CITY OF ALBUQUERQUE

January 29, 2026

RE: 8004 Fuji Ct NW
Grading and Drainage Plan
Engineer's Stamp Date: 1/23/26
Hydrology File: E10D088
Case # HYDR-2025-00003

ENGINEER'S SEAL	LOT 13 BLK 13 U 5 VC 8004 FUJI CT. NW GRADING AND DRAINAGE PLAN	DRAWN BY DEM
		DATE 10-8-20
1/30/26		SHEET # C1
DAVID SOULE P.E. #14522		JOB #

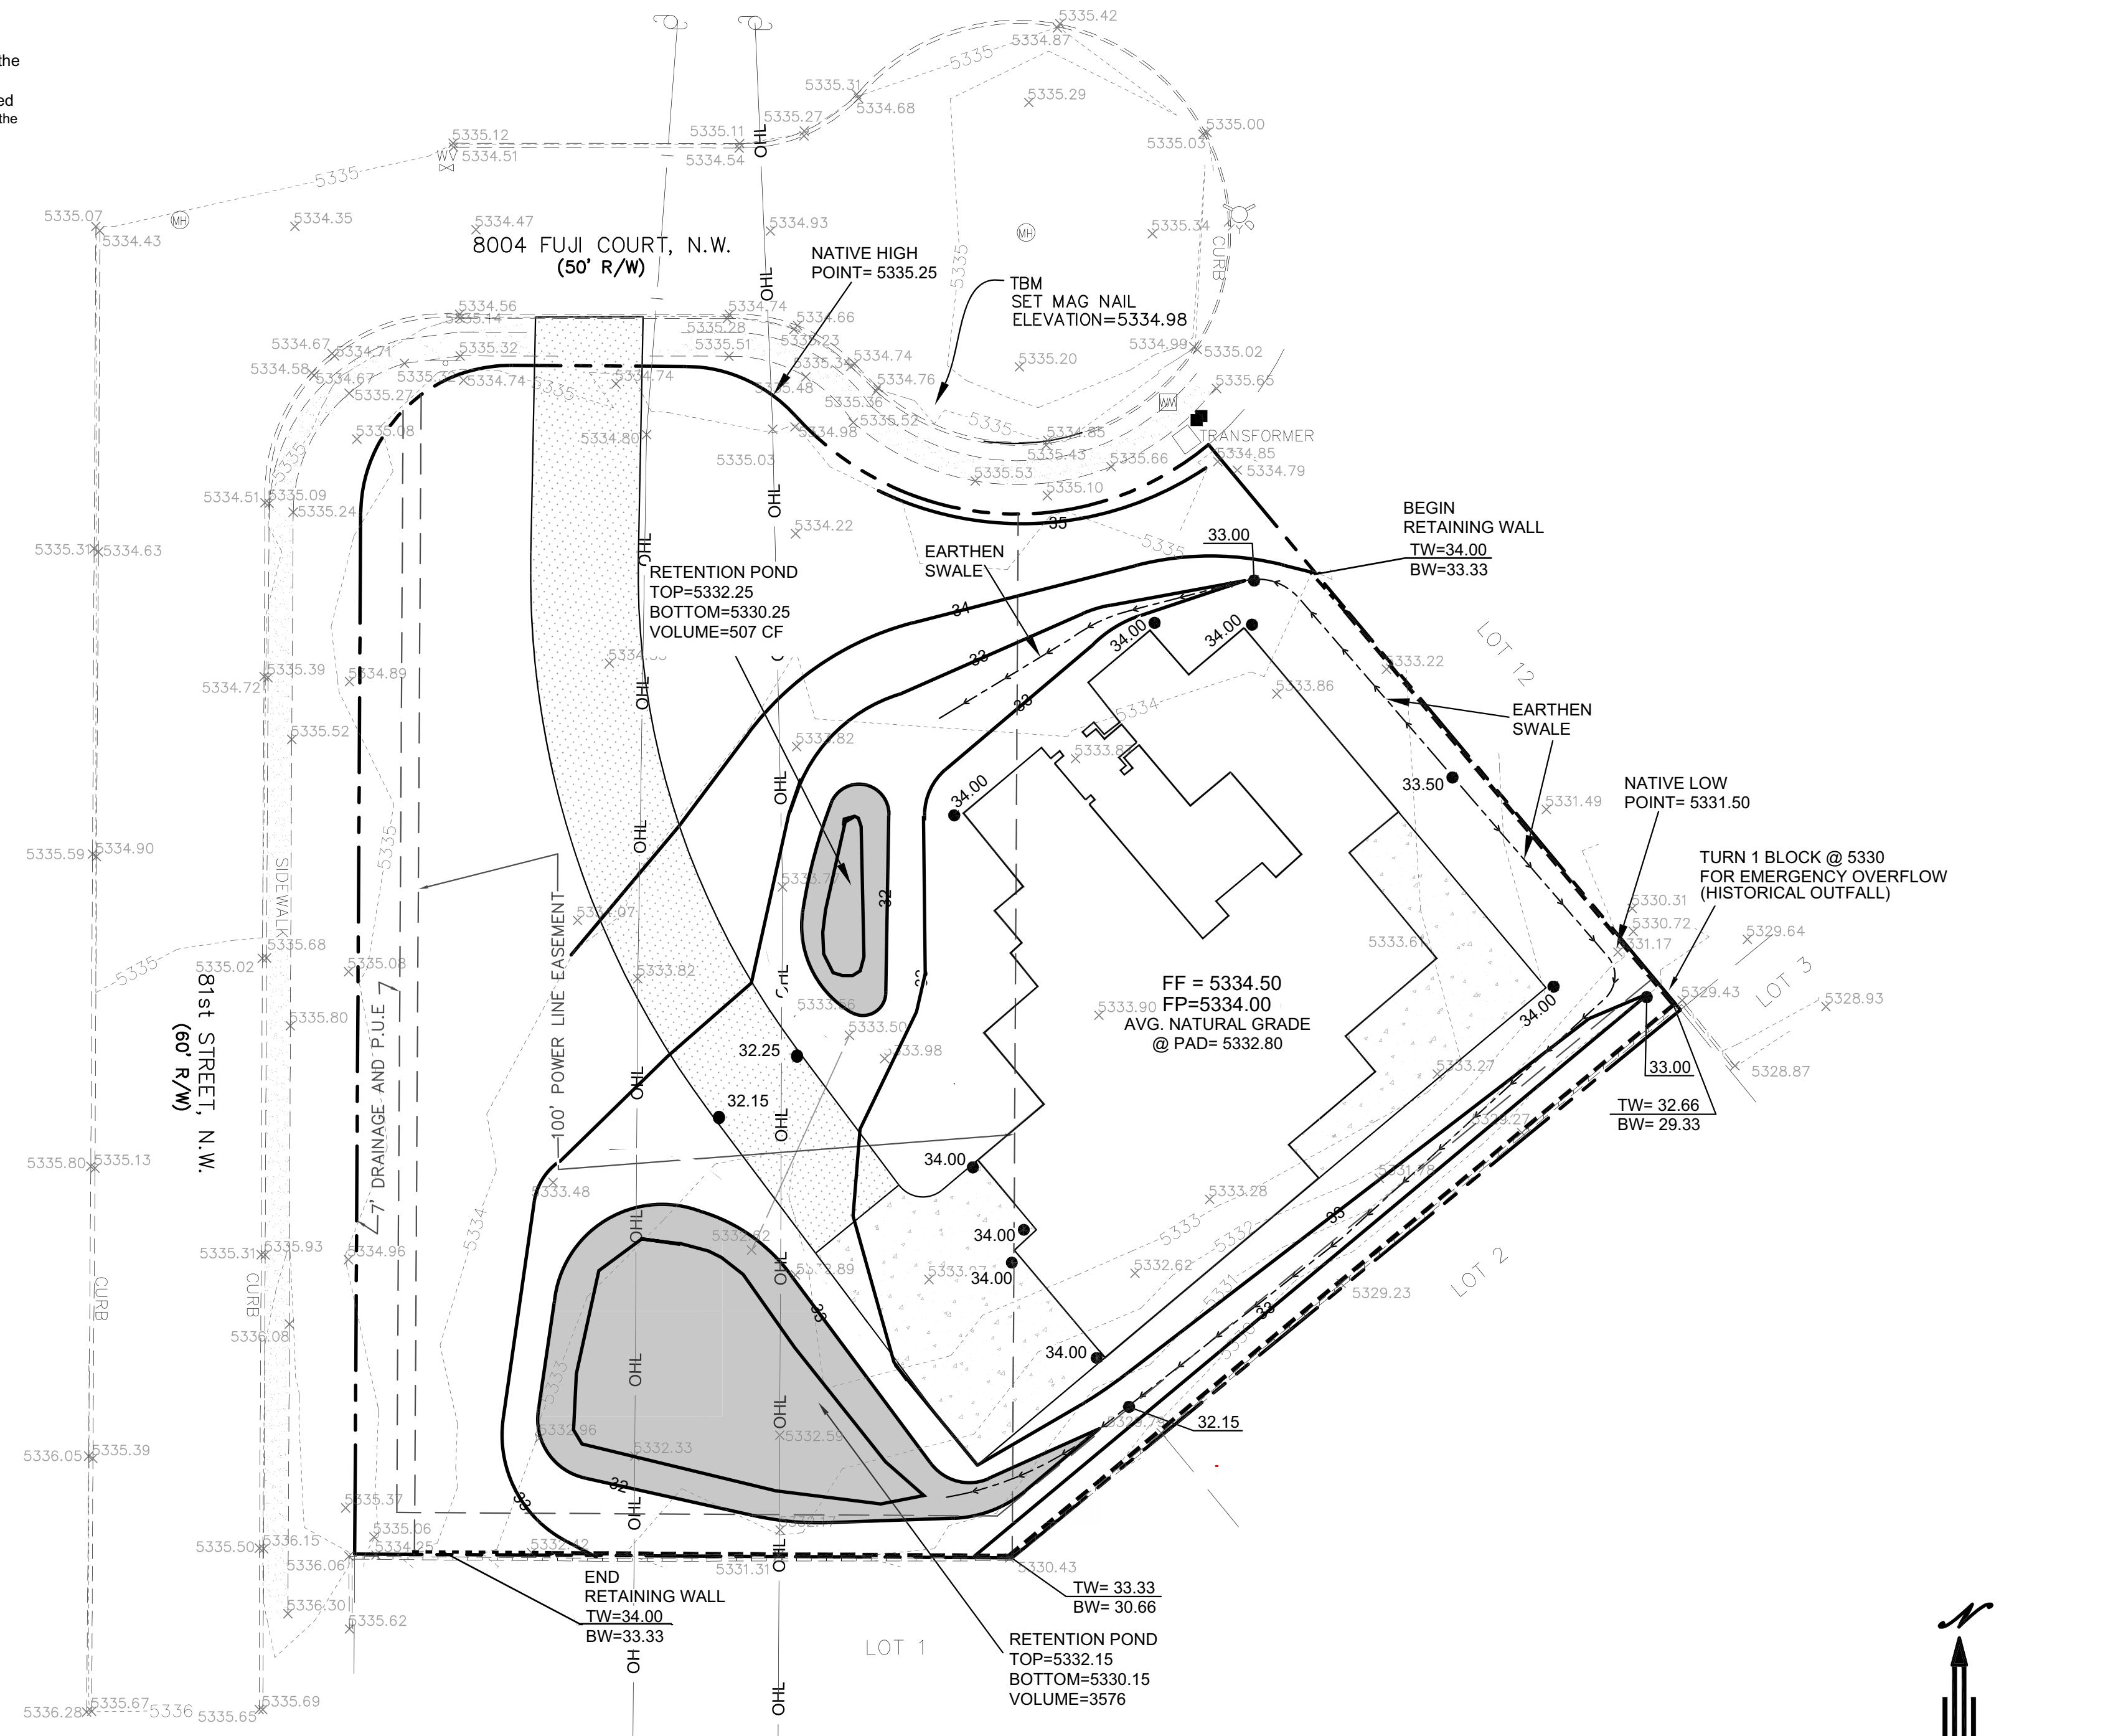
1. Thank you for updating the pond narrative. Per my last comments please update SAD 228 to SAD 227.

2. The retaining wall is still shown set back from the 5334' contour in the plans. Per previous comments and our phone call on 1/22/26, please extend retaining wall on the northeast side of the property to the 5334' contour line.
